**Consultation Response from KC,
Lead Local Flood Authority**
2020/93650 Former North Bierley Waste Water Treatment Works, Cliff Hollins Lane, Oakenshaw, BD12 7ET
Discharge of Condition 3 (access road). Condition 4 (internal estate road) and Condition 5 (landscape works) of previous permission no. 2020/91488 for reserved matters application pursuant to application no. 2016/92298 for outline application for re-development of former waste water treatment works following demolition of existing structures to provide employment uses (use classes B1(c), B2 and B8)
Date Responded: 27/03/2023.
Responding Officer: Martin Stephenson
Responding Ref: 1
Previous response by the LLFA

Discharge of Drainage Conditions

- No. 4 (internal estate road)

S38 RE-PROFILED BROOK DIVERSION

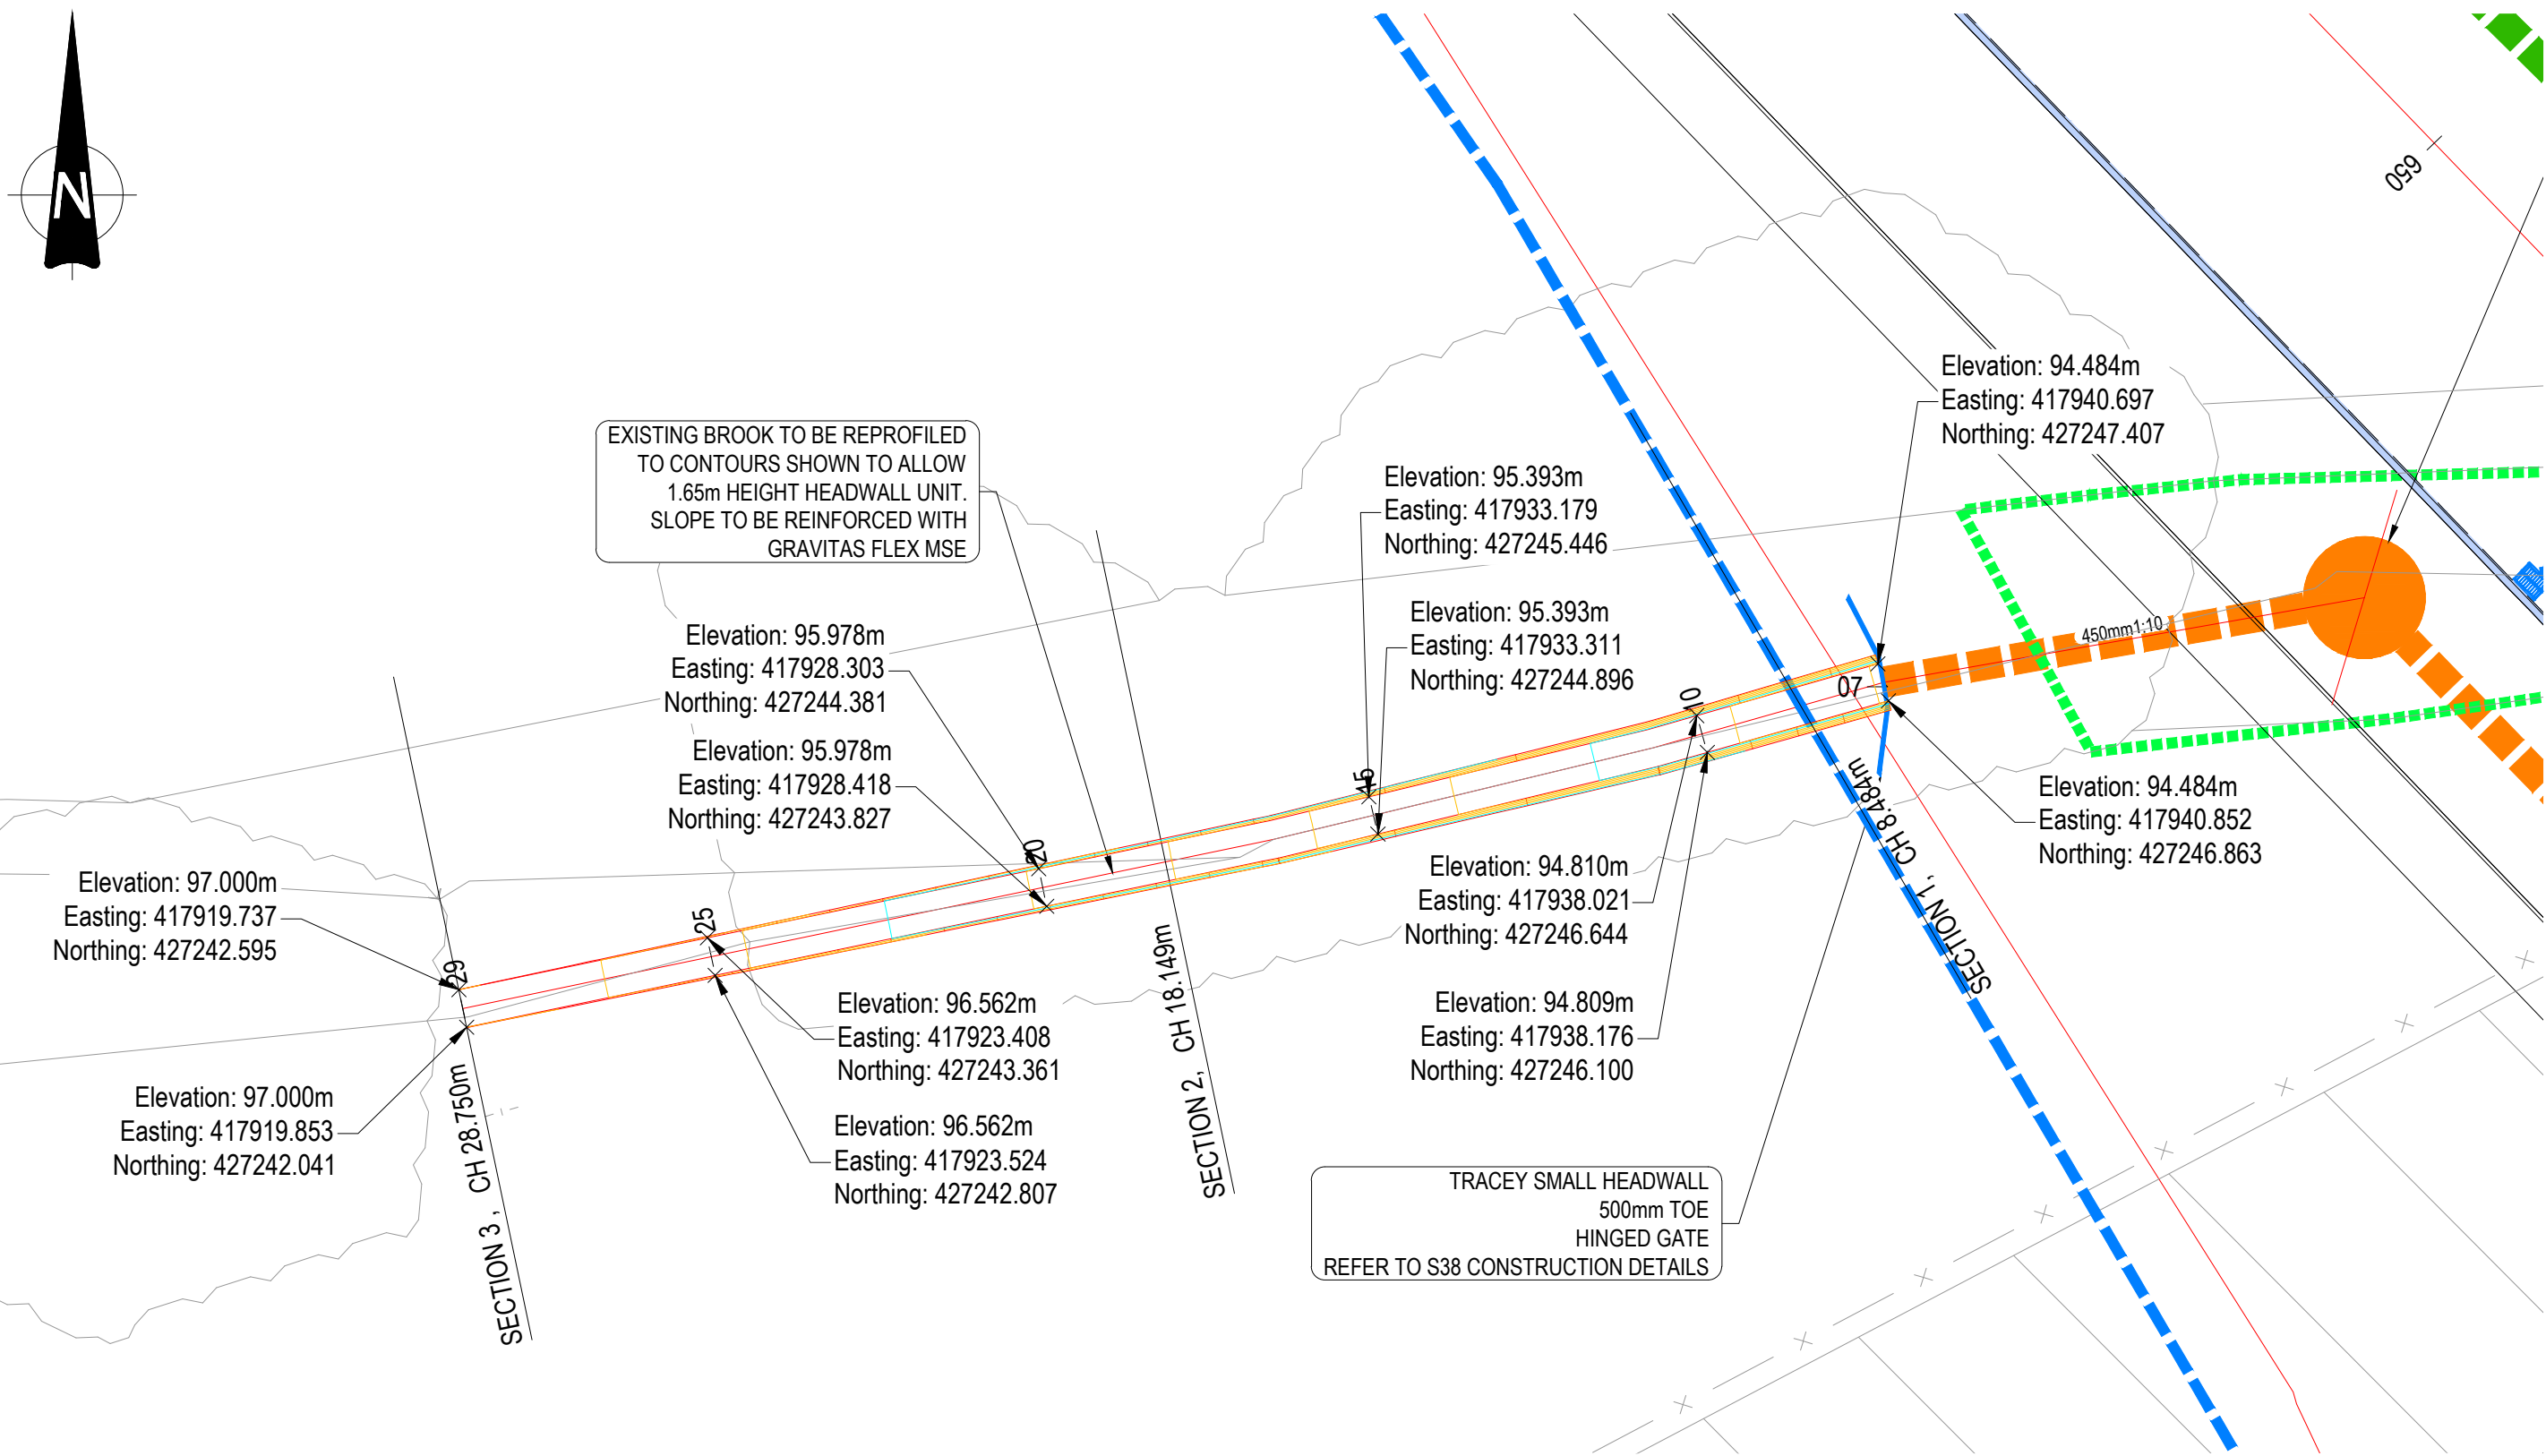
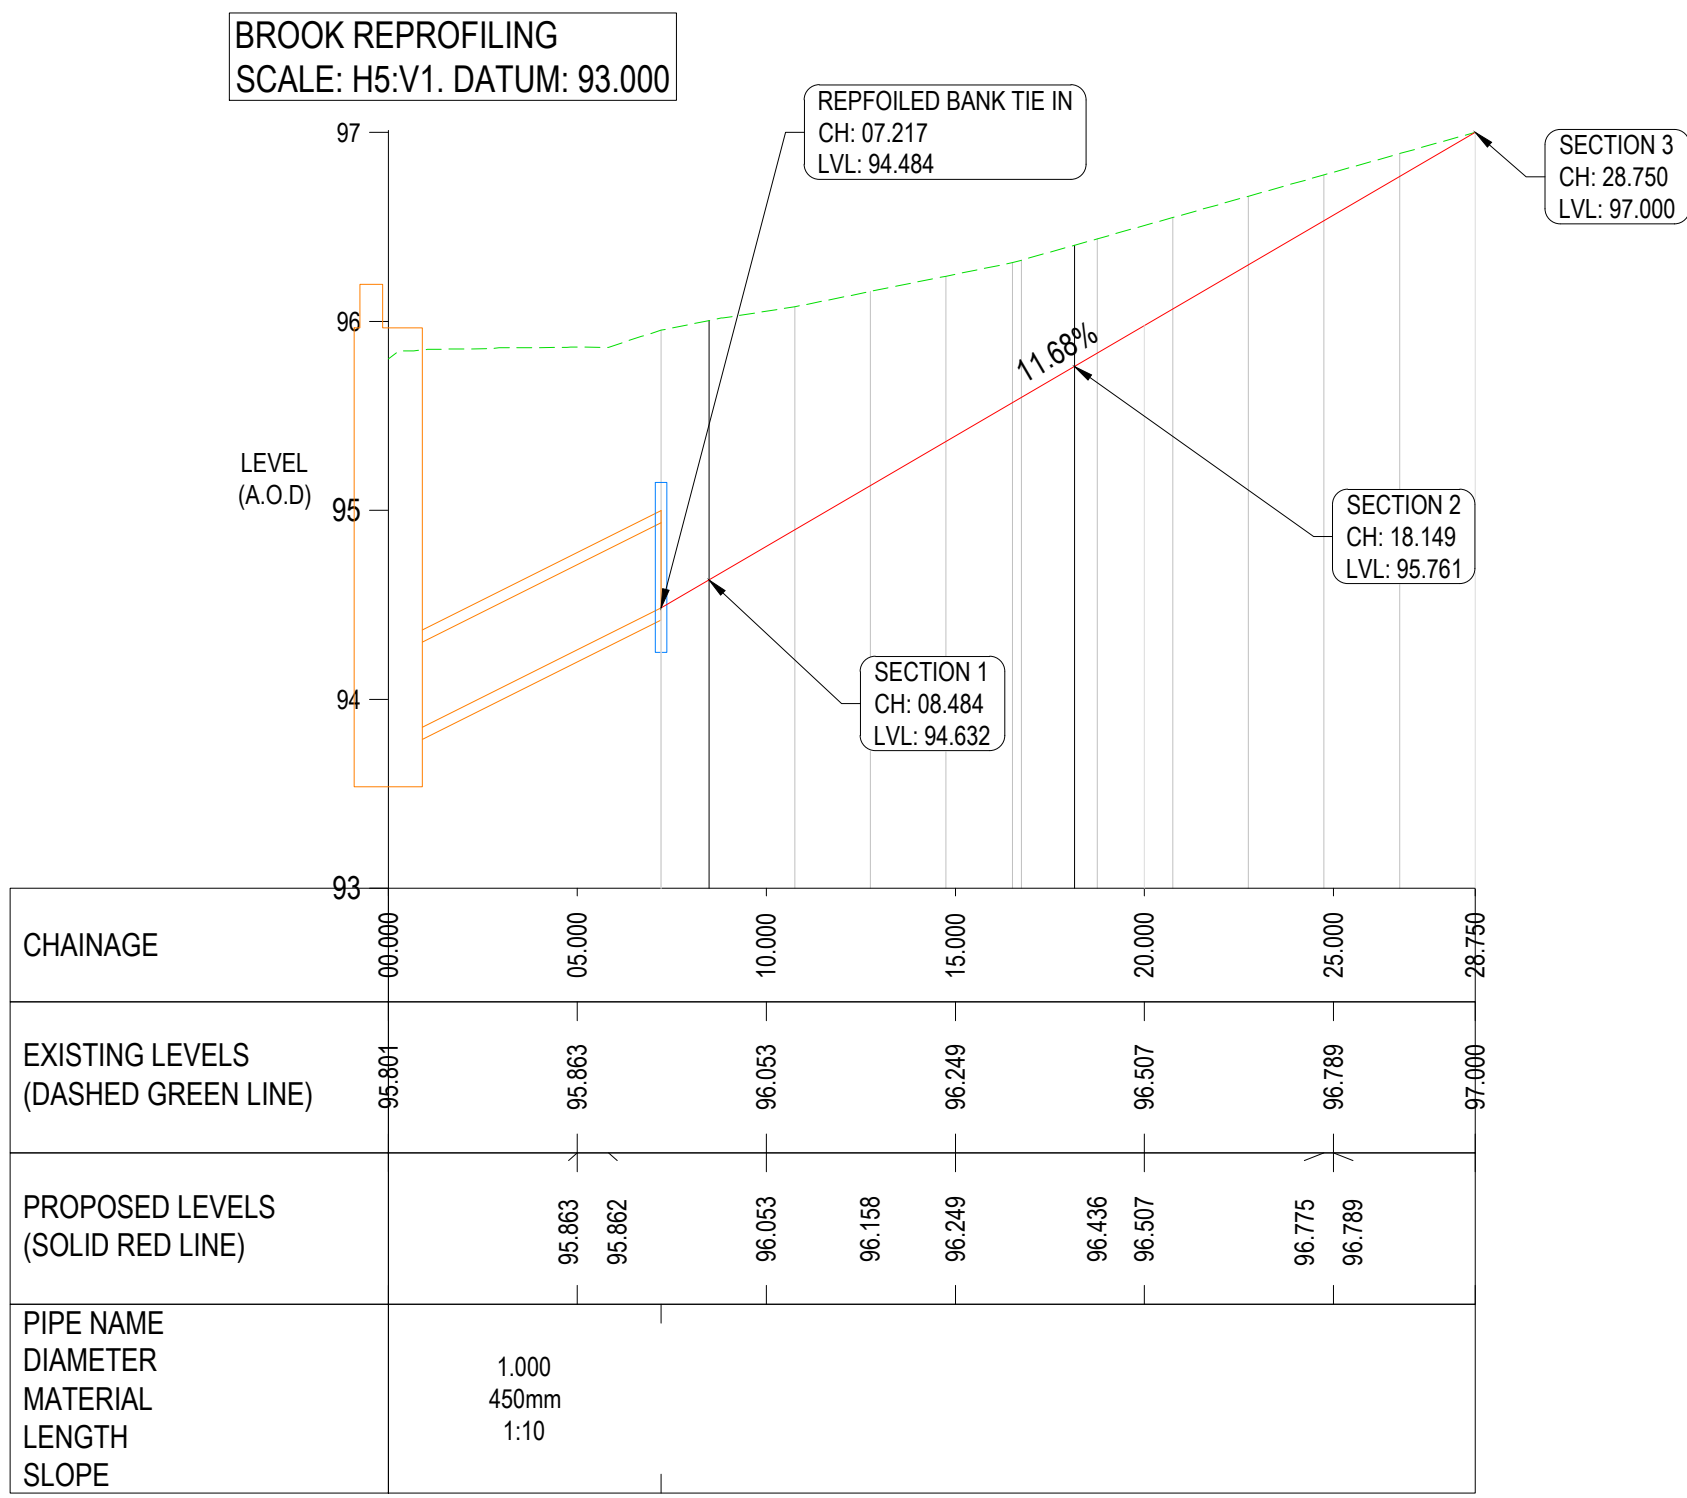
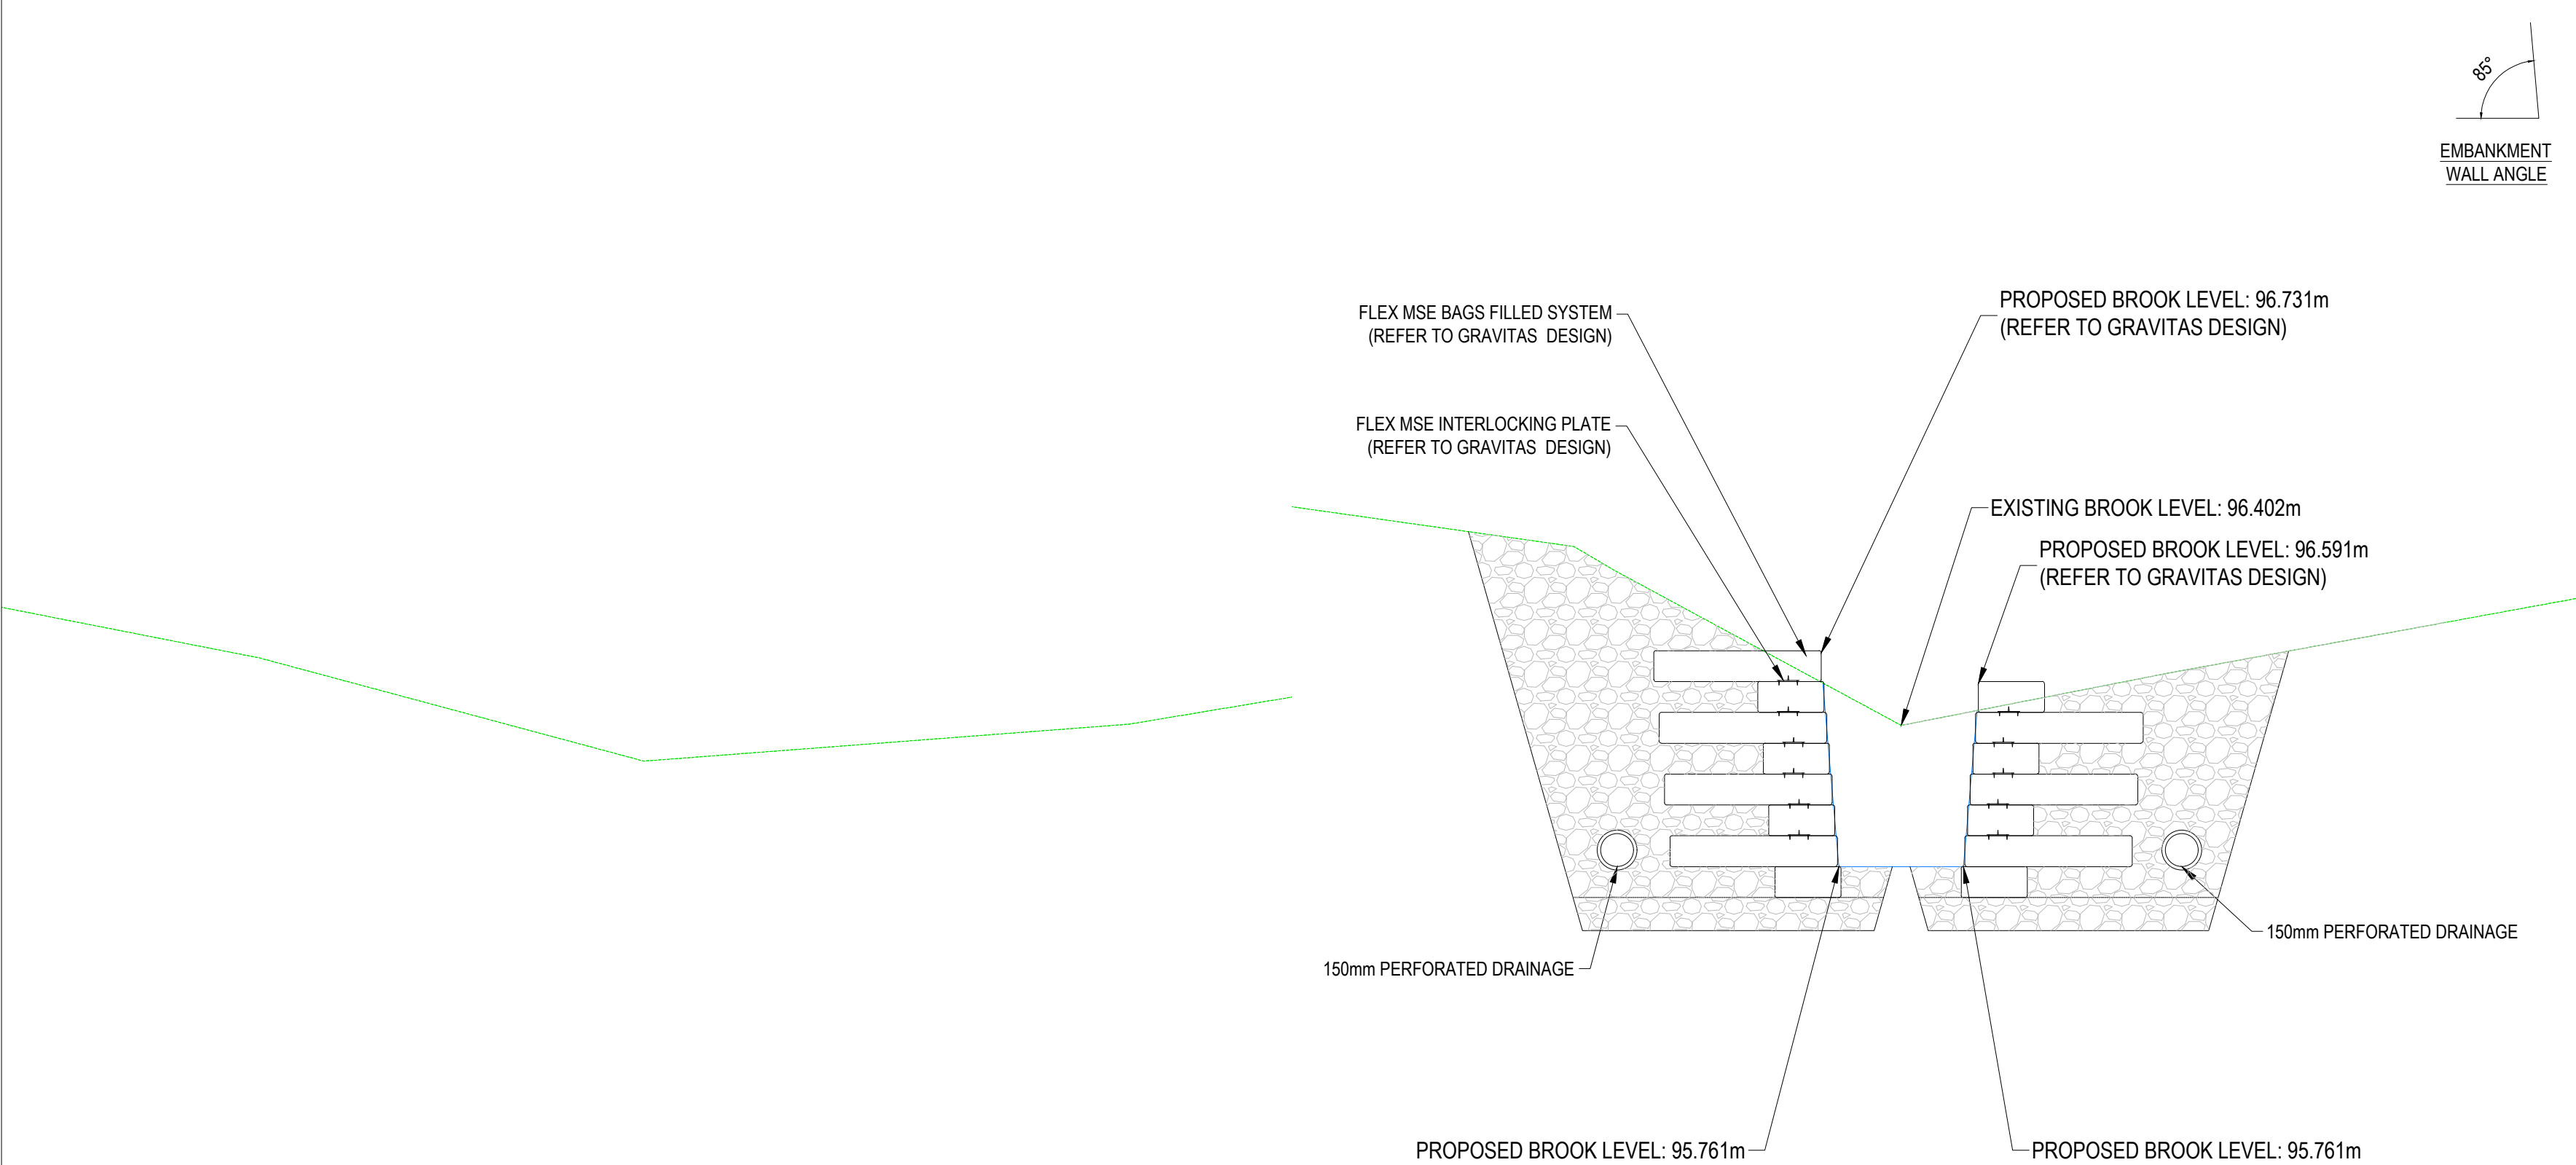
With regard to the S38 Reprofiled Brook Diversion drawing, the discharge of condition is also the responsibility of the S38 team. Note, however the reprofiling of an existing watercourse is subject to a Land Drainage Consent which can be applied for by the developer via the Kirklees Council website (<https://www.kirklees.gov.uk/beta/flooding-and-drainage/work-on-watercourses.aspx>).
